Appeal Decision

Appeal Ref: APP/R5510/X/21/3269017

17 Woodgate Crescent, Northwood HA6 3RB

- The application was made under section 192(1)(b) of the Town and Country Planning Act 1990 as amended.
 - The development for which a certificate of lawful use or development is sought is described as 'proposed construction of a single storey outbuilding within the curtilage of the dwelling house, following the demolition of two existing outbuilding. The proposed outbuilding will be constructed in the same vicinity and on the same level as the demolished gym toom outbuilding.'
-

Drawing title
PROPOSED OUTBUILDING 2 - SWIMMING POOL
PROPOSED SITE PLAN (BLOCK PLAN) AND
PROPOSED SITE SECTION

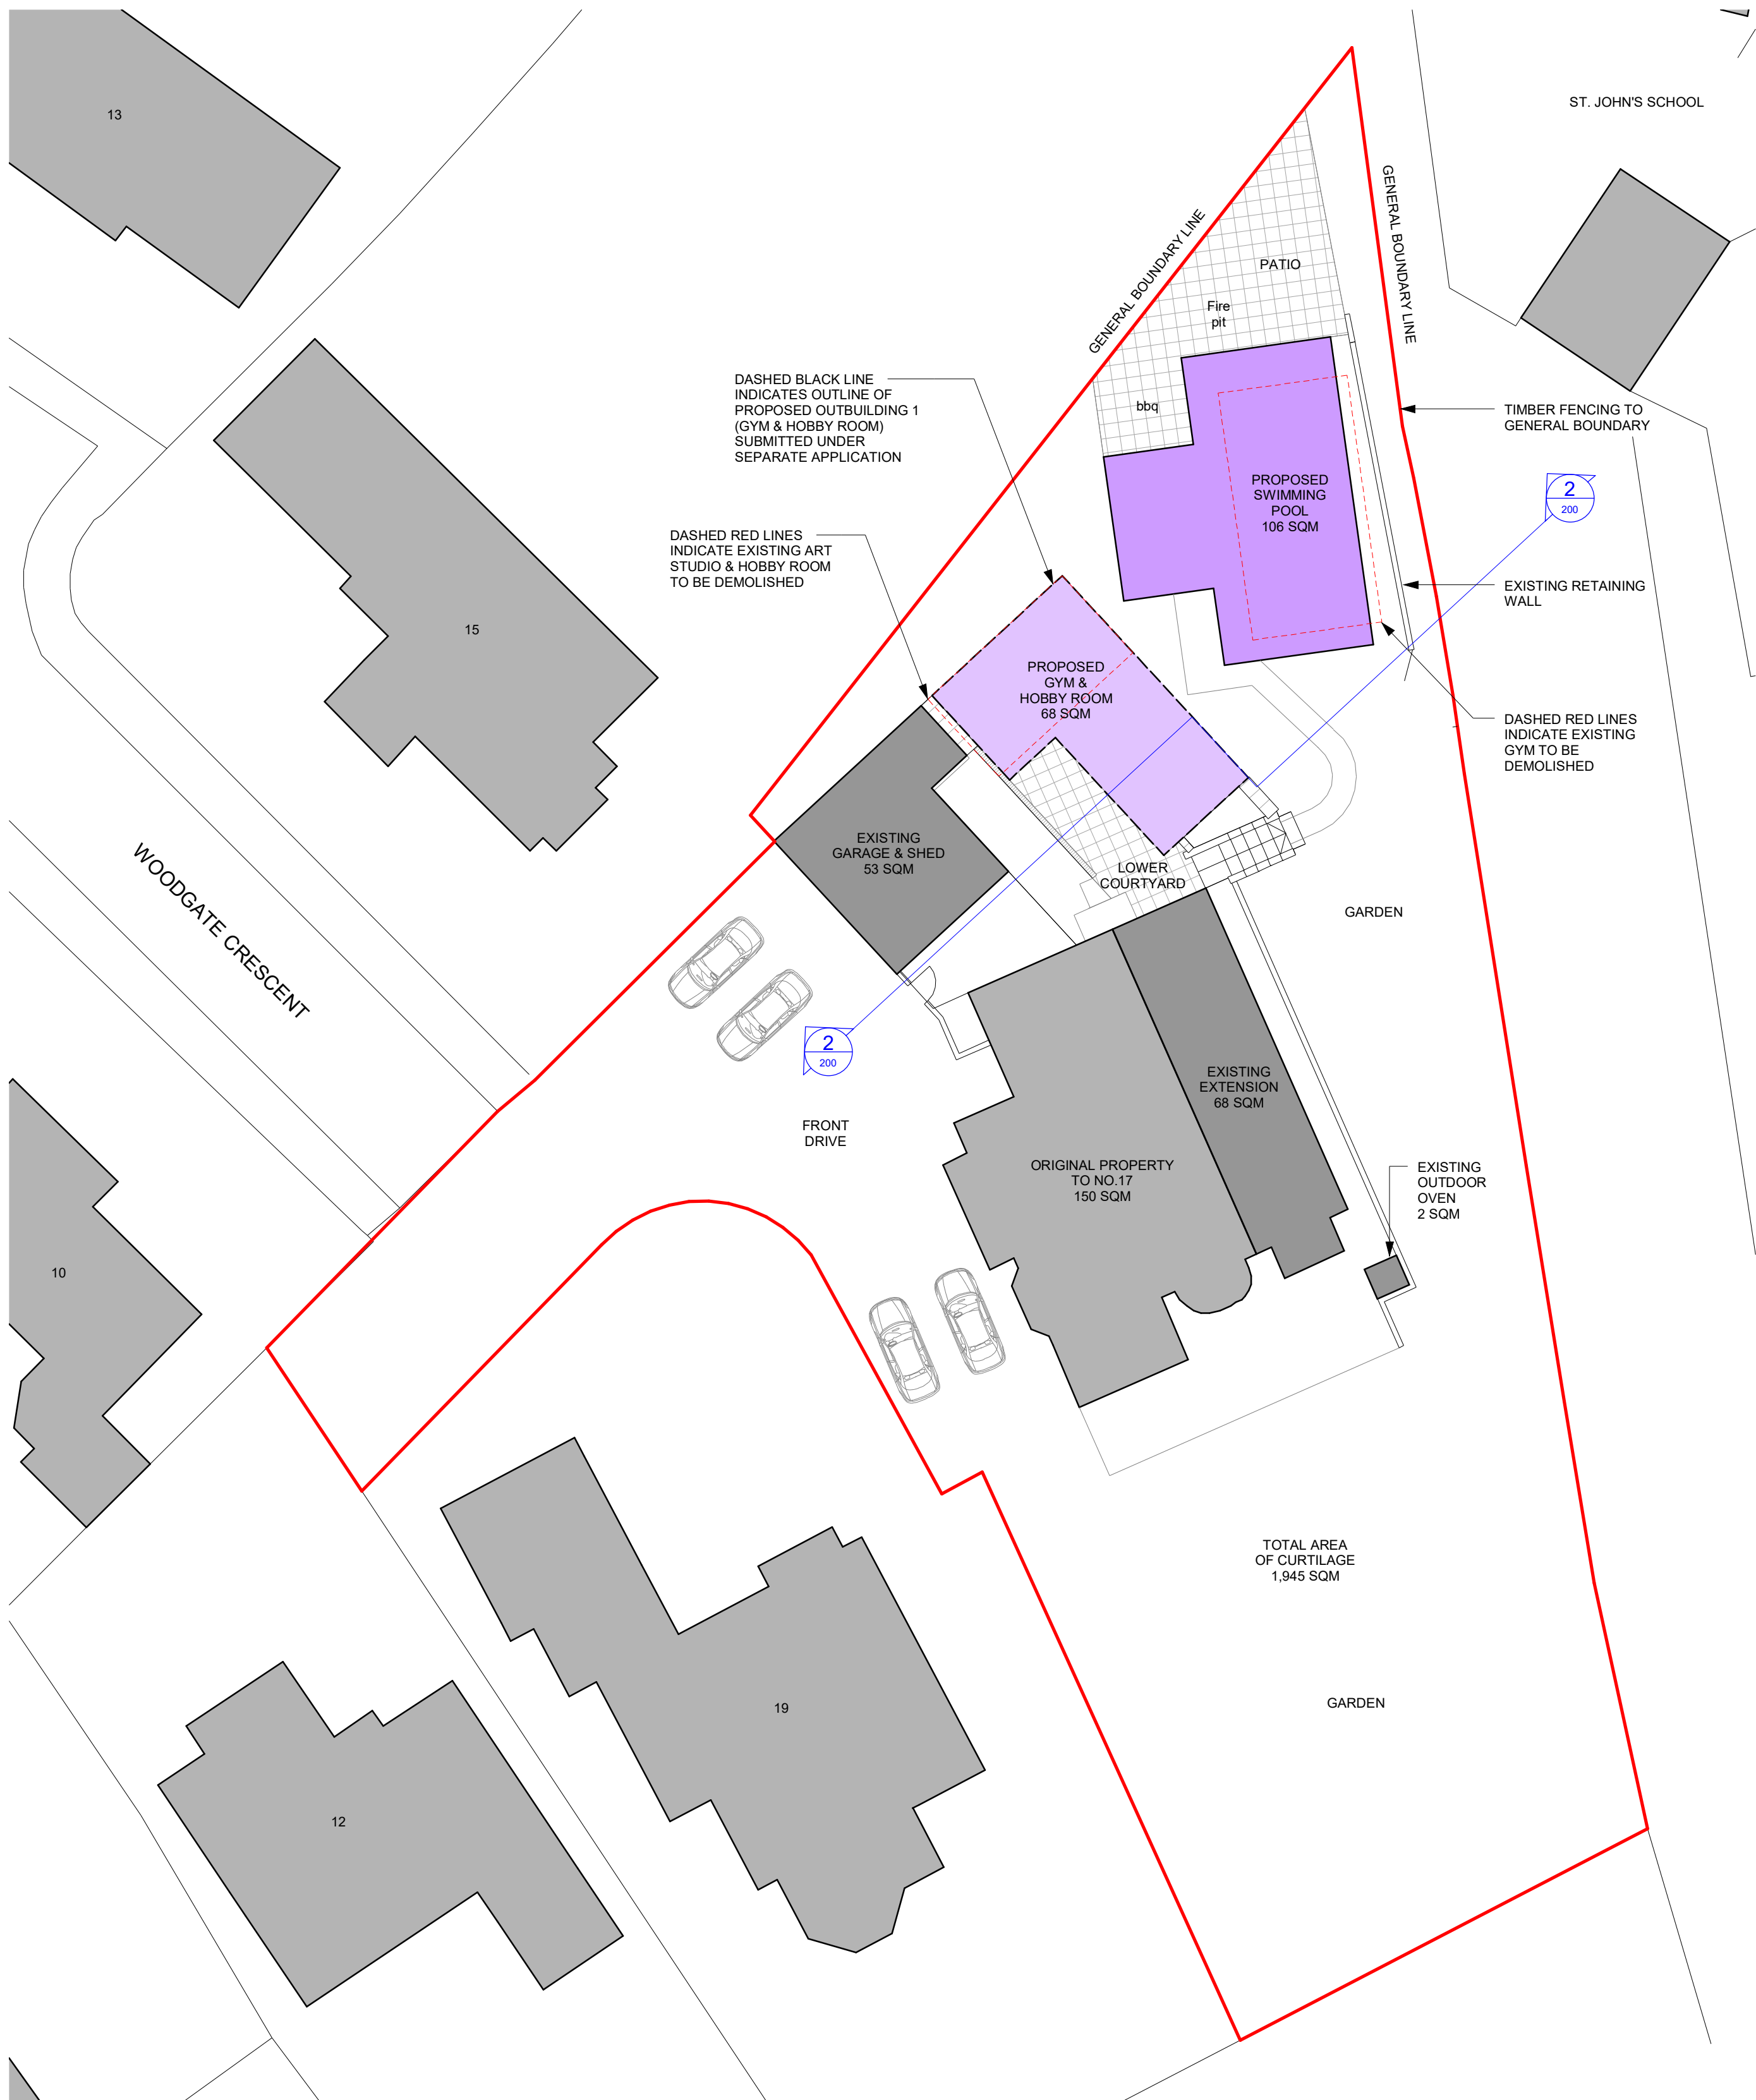
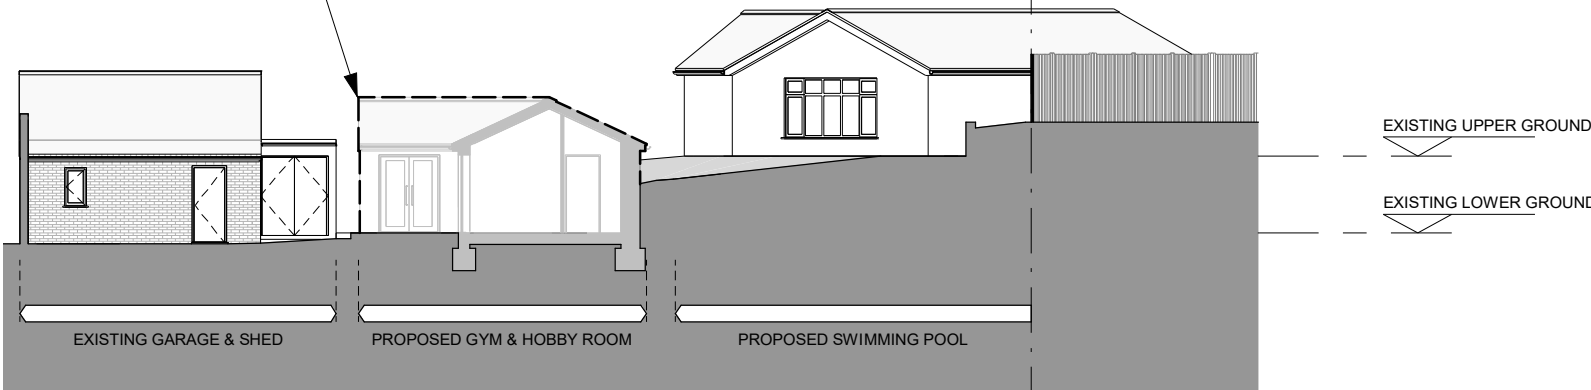
12. However, whilst the Council did not refuse the application because of any breach of the limitations under E.1 of the GPDO, there remains significant ambiguity in relation to where the boundary of the appeal site lies. I have had regard to all the evidence before me, including the findings of the various reports undertaken in relation to the boundary dispute and observations on my site visit. Furthermore, I understand that the matter is now for consideration by the courts. On that basis, I do not consider that there is sufficient clarity in the application before me that would enable me to conclude, as a matter of fact and degree, that the outbuilding would not lie within 2m of the boundary of the curtilage of the dwellinghouse. Consequently, given that the proposed height of the building exceeds 2.5m, it would not comply with limitations E.1 (e)(ii) of the GPDO.
